Re: 221543RT1- DAWSON

Project Customer:	-	Project Name:	221543RT1- DAWSON
Lot/Block:	-	Subdivision:	-
Address:	6983 US 401 HWY FUQUAY	Model:	-
City:	VARINA	State:	North Carolina

Job 221543RT1	Truss E01	Truss Type Roof Special	Qty 6	Ply 1	DAWSON Job Reference (optional)	Paragon ID: 36449 P3863153
------------------	--------------	----------------------------	----------	----------	------------------------------------	-------------------------------

Job 221543RT1	Truss E01	Truss Type Roof Special	Qty 6	Ply 1	DAWSON Job Reference (optional)	Paragon ID: 36449 P3863153
------------------	--------------	----------------------------	----------	----------	------------------------------------	-------------------------------

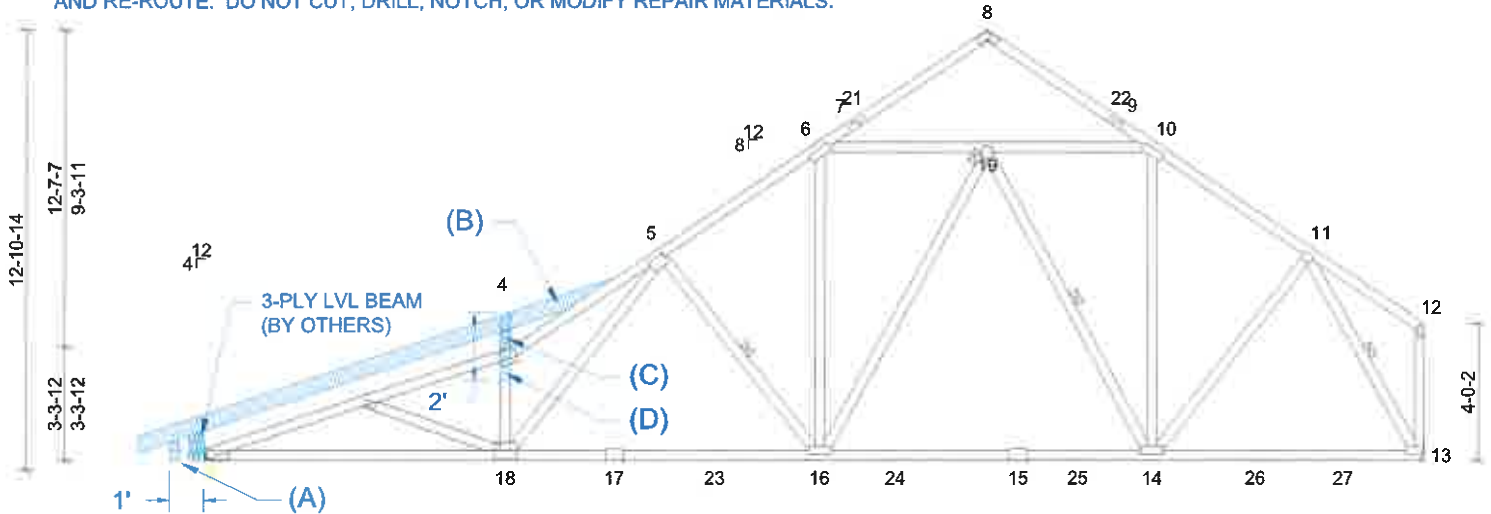
**REPAIR:**

- 1) CHANGE LEFT BEARING CONDITION TO HANGER (BY OTHERS) AS SHOWN.
- 2) OVERFRAME THE 4/12 PITCH AS SHOWN.

(A) VERTICALLY CUT AND REMOVE TRUSS TAIL. LUMBER TO BE CUT CLEANLY AND ACCURATELY AND THE REMAINING PLATE(S) MUST BE FULLY EMBEDDED AND UNDISTURBED. DO NOT OVERCUT.

(B) ADD (1) NEW 2 X 6 SP No.2 RAFTER AS SHOWN - CUT TO FIT TIGHT. BIRDSMOUTH CUT AT 3-PLY BEAM MUST HAVE MINIMUM 2" OF BEARING ON BEAM AND BE ABLE TO WITHSTAND MINIMUM OF 50# UPLIFT.

(C) ADD (1) NEW 2 X 4 SP No.2 MEMBER AS SHOWN - CUT TO FIT TIGHT.

(D) APPLY 2x4x2' SP No.2 SCAB TO ONE SIDE OF TRUSS AS SHOWN. ATTACH TO 2x6 RAFTER WITH CLUSTER OF (4) 10d(3" X 0.131") NAILS AND TO ALL OTHER MEMBERS WITH (2) ROWS OF 10d (3" X 0.131") NAILS: SPACED @ 3" OC.
